# ENG-PPR19009-R3-TIS.pdf Markup Summary

Figure 11a
**Short-Term
(Phase 1 and 2 Only) Total Traffic**
Monument Academy (LSC #184820)

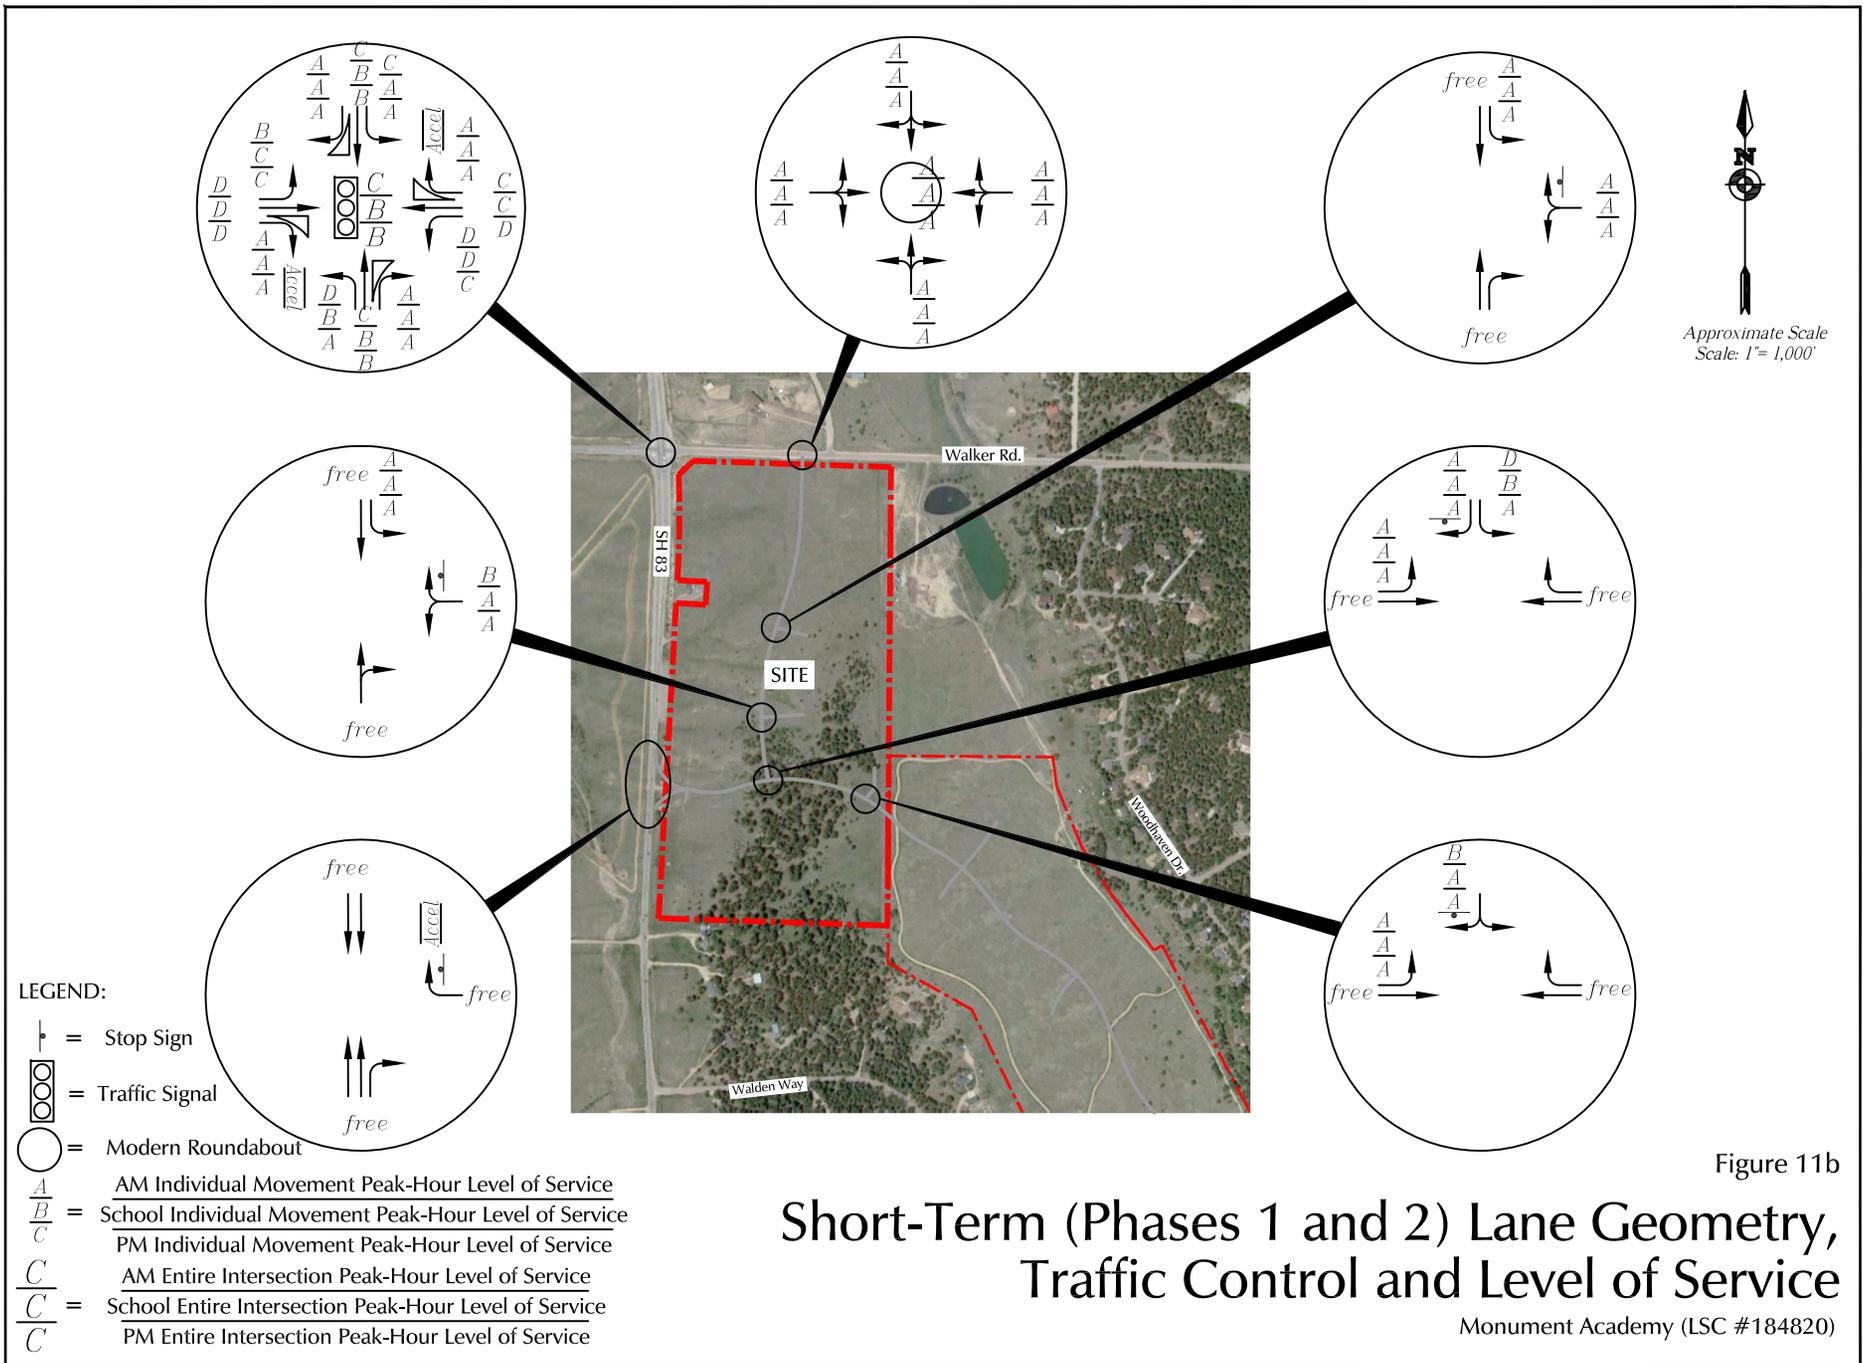
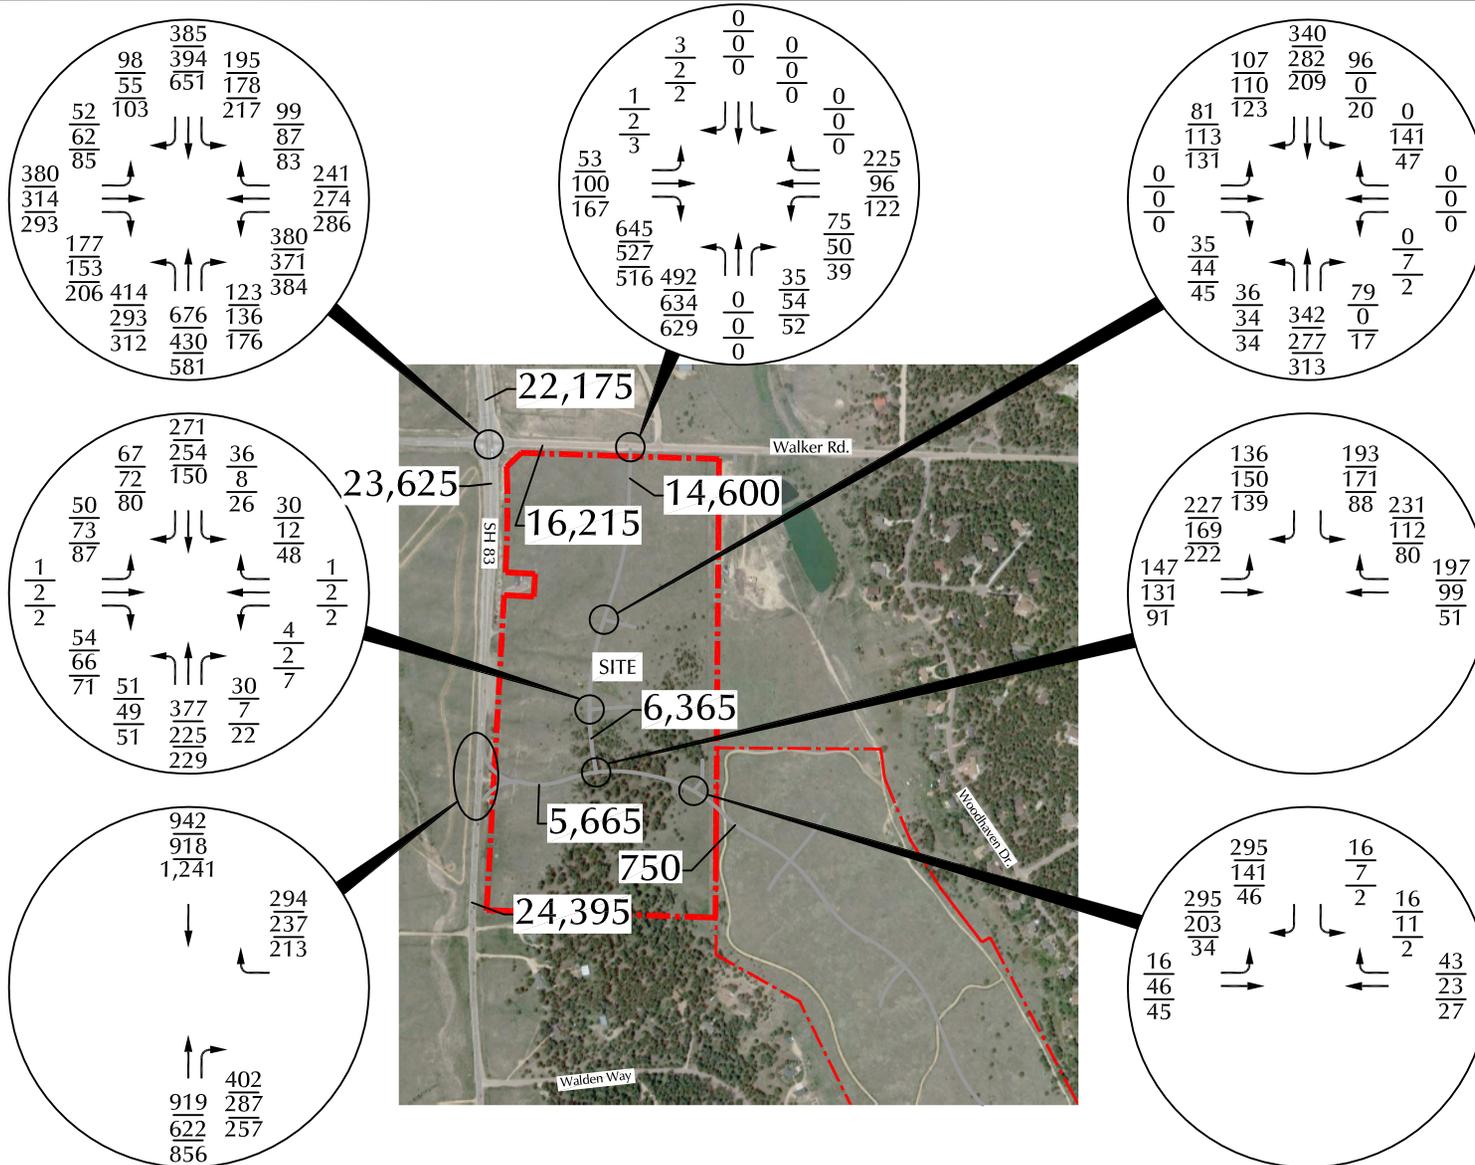
Adjust all figures to show right-in only.

Figure 12a
Year 2040
Total Traffic
 Monument Academy (LSC #184820)

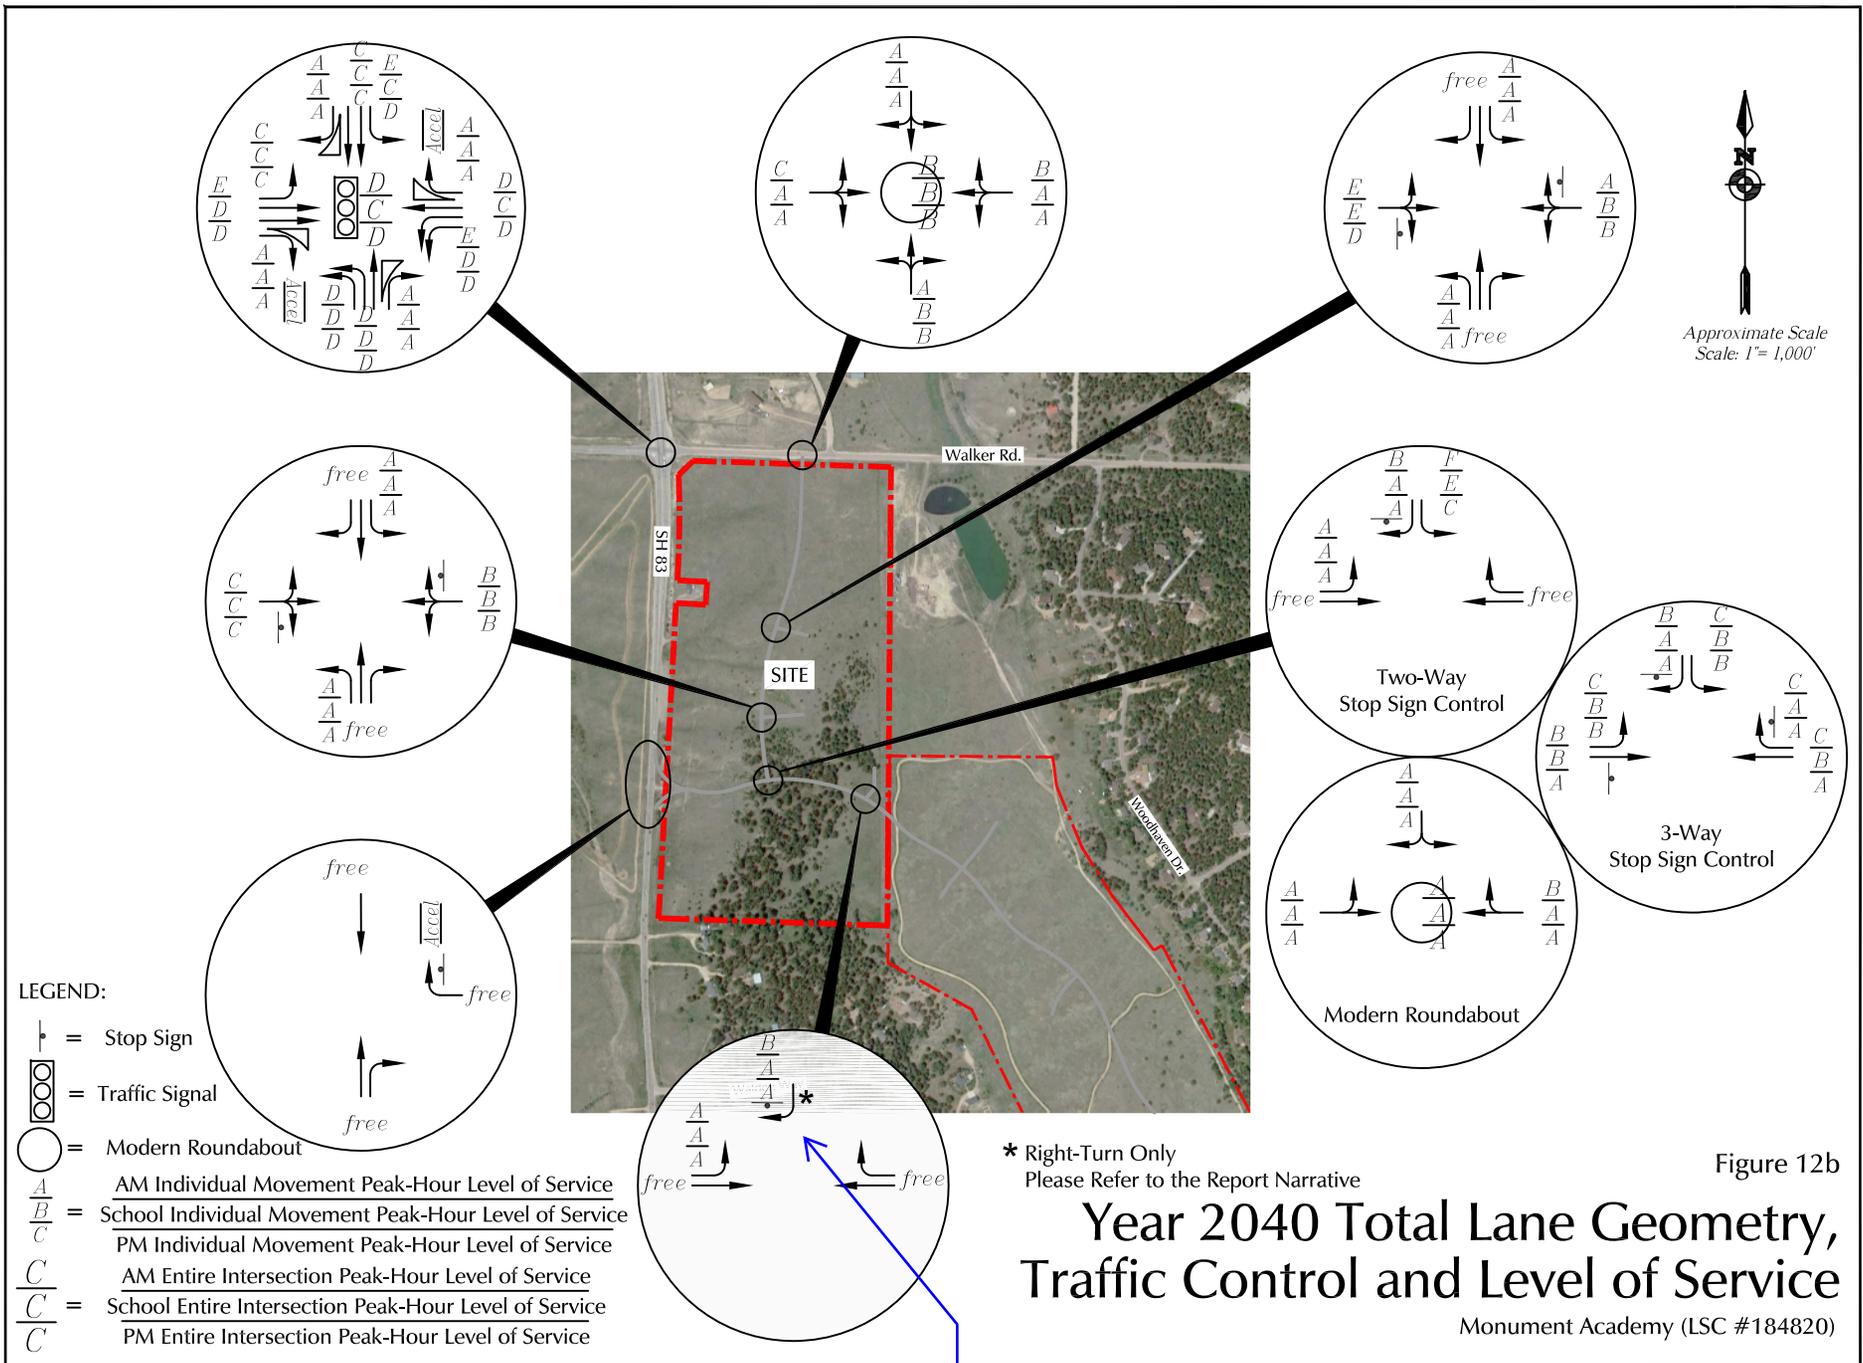
Provide narrative discussion.
